Reference: 2025/93572

Proposal: Outline application with all matters reserved, bar vehicle access into the site, for erection of up to 123 dwellings with associated works including open space, landscaping, drainage infrastructure. | Land South of, Barnsley Road, Upper Cumberworth, Huddersfield, HD8 8NN

Summary of Comments

Layout For Illustration Purpose Only.

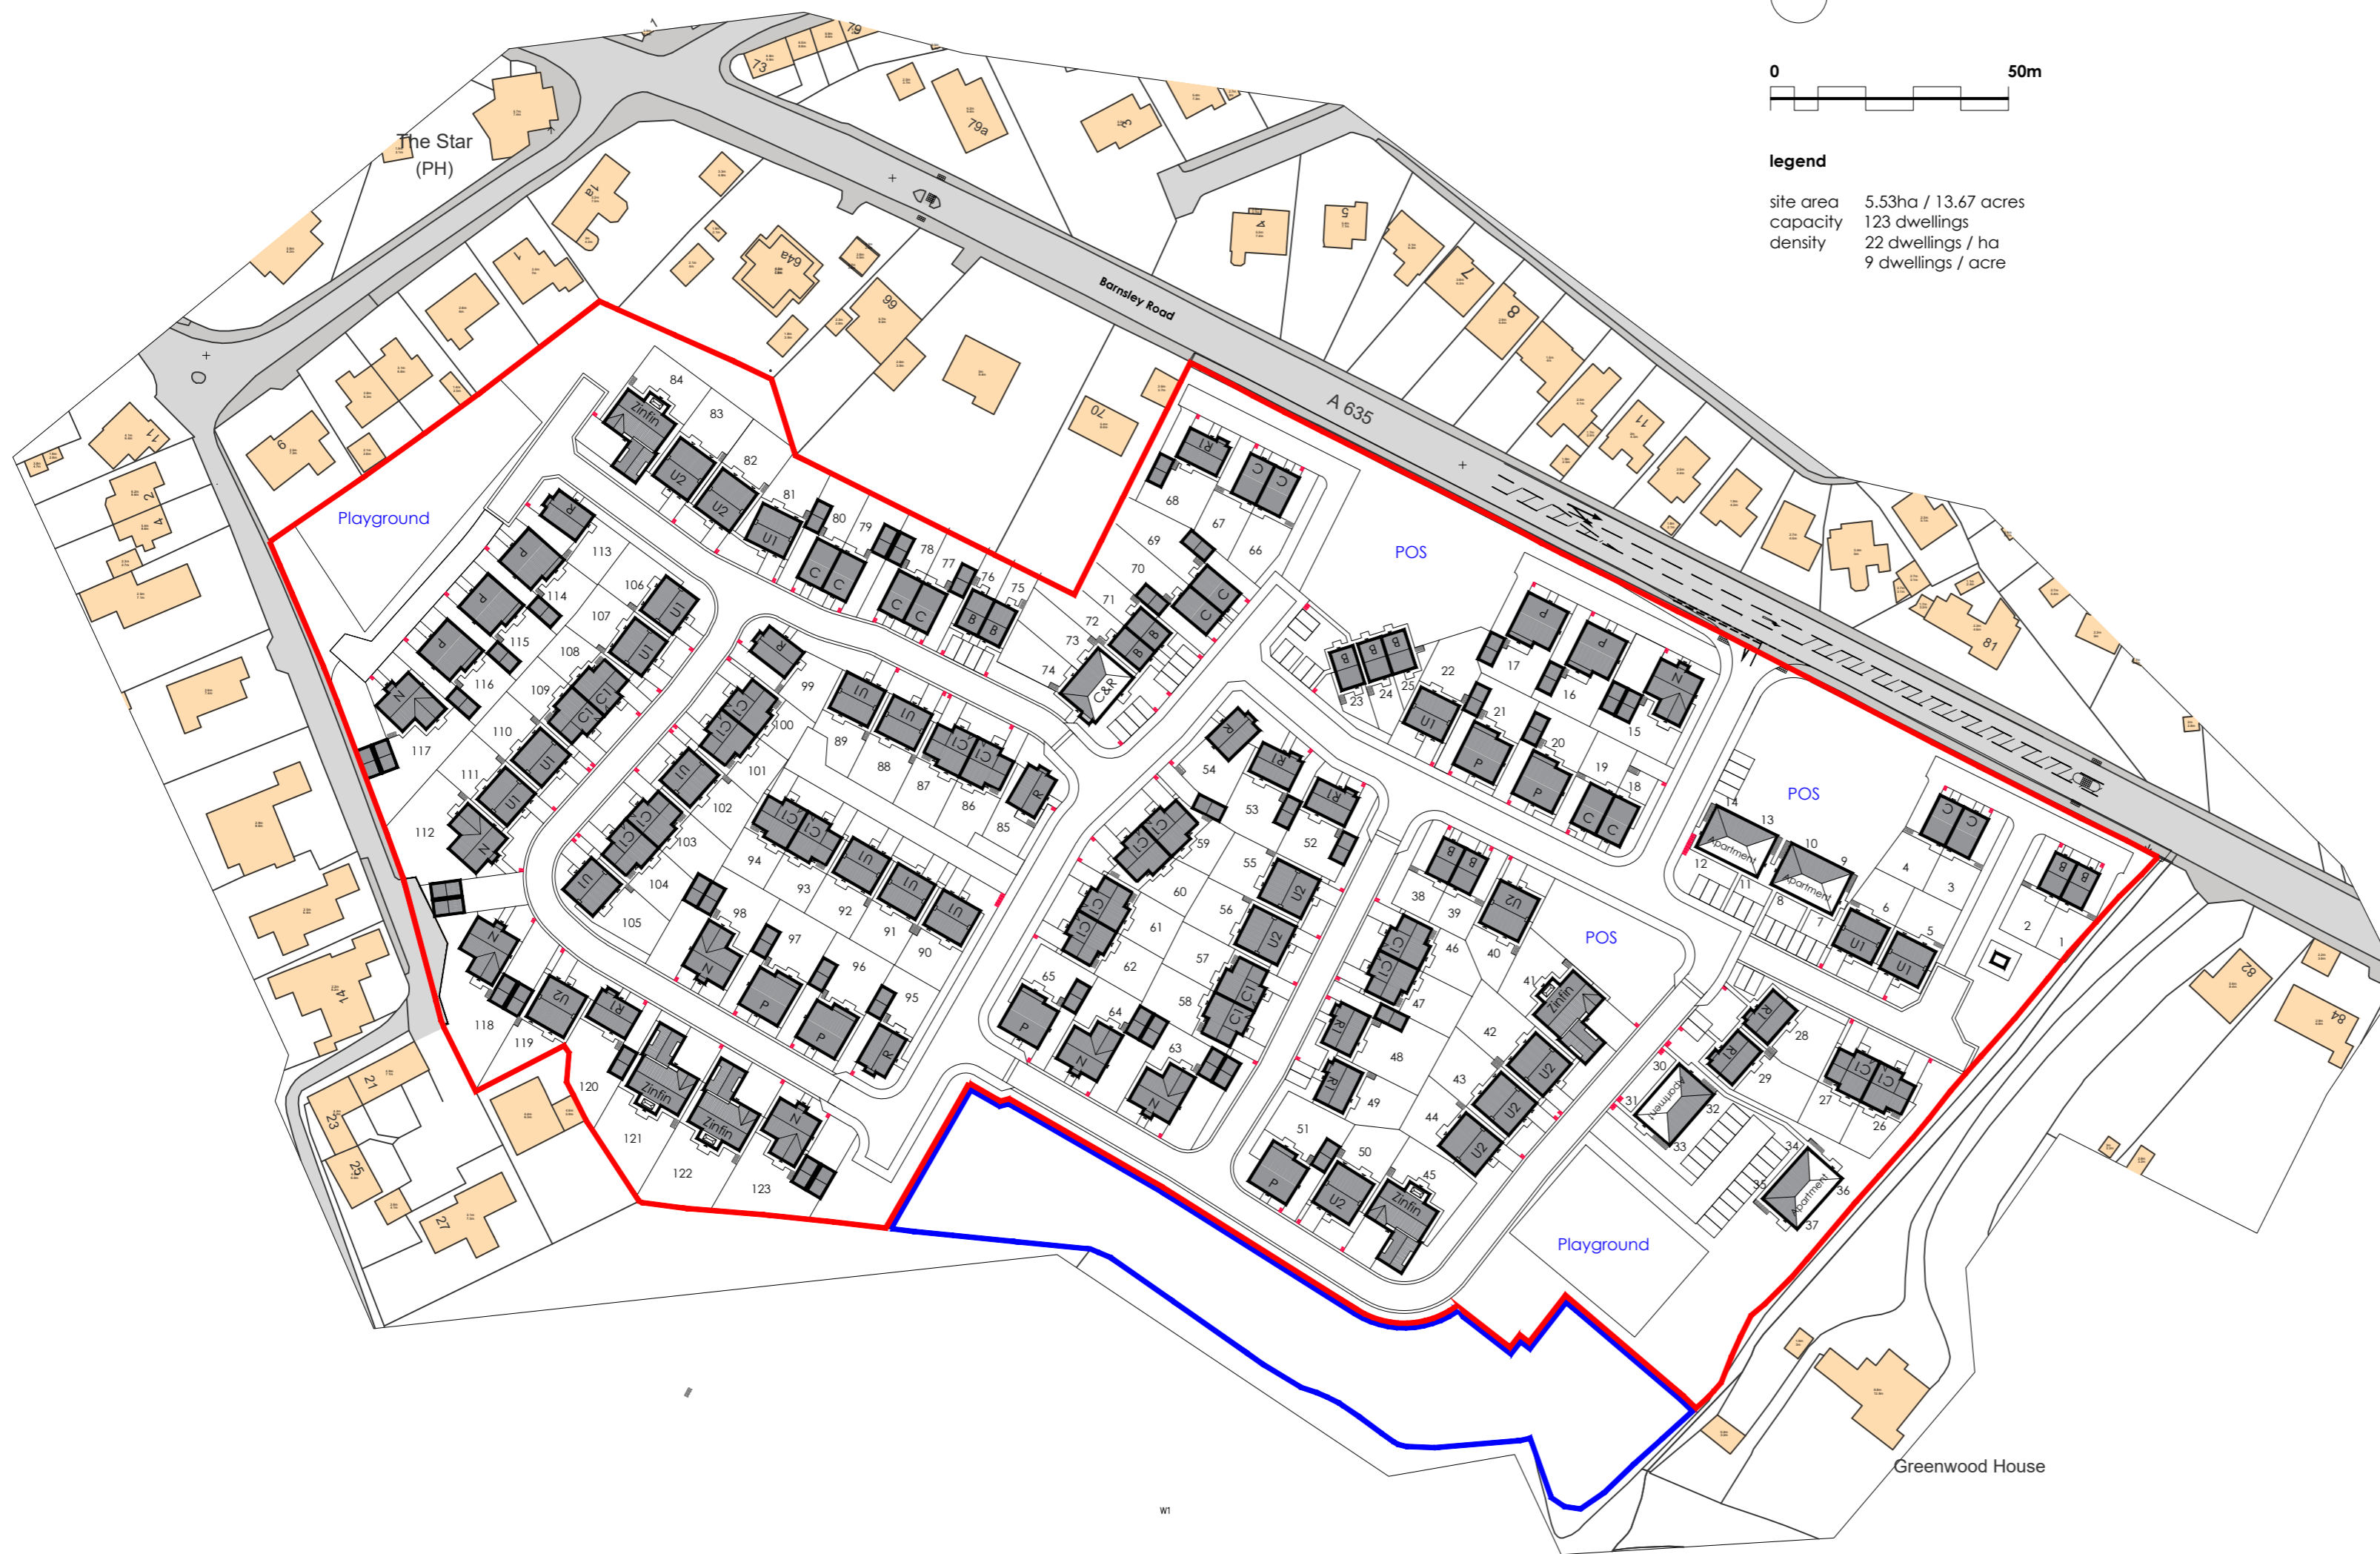
The proposed mitigation is a 15-20 metre planted buffer zone. Most documents refer to a 15 metre buffer, but there is also reference to a 20 metre construction offset.

The applicant's assertion that a 15 metre buffer would mitigate impacts on ancient woodland is currently unsupported by evidence or analysis. This is perhaps due to a misconception that a 15 metre buffer zone is a 'standard' rather than a 'minimum' and does not need to be tailored to the proposal. For example, the Arboricultural Impact Assessment refers to the "*influencing distance of 15 metres (statutory buffer zone)*" and the Design and Access Statement refers to the 15 metre buffer as "*significant*".

It is stated that the buffer would be planted, although we note that the buffer zone is not within the red line boundary. It is not clear whether public access into the buffer would be encouraged or deterred, or what the likely increase in footfall within the ancient woodland would be. There are a number of public rights of way in the area, including through Stephen Wood. The illustrative layout shows a potential connection with the right of way network.

The standing advice states that larger buffer zones are more likely to be needed if development is close to residential areas or if a significant increase in traffic is anticipated. For large developments, we recommend buffer zones of **at least 50 metres** as a precautionary principle, unless it can be clearly demonstrated that smaller buffers would suffice.

Additionally, for a development of this size, part of the buffer should be treated as land that needs safeguarding rather than public open space. For example, if a 50 metre buffer is provided we would recommend **access is discouraged for a minimum of 15 metres** adjacent to the ancient woodland.
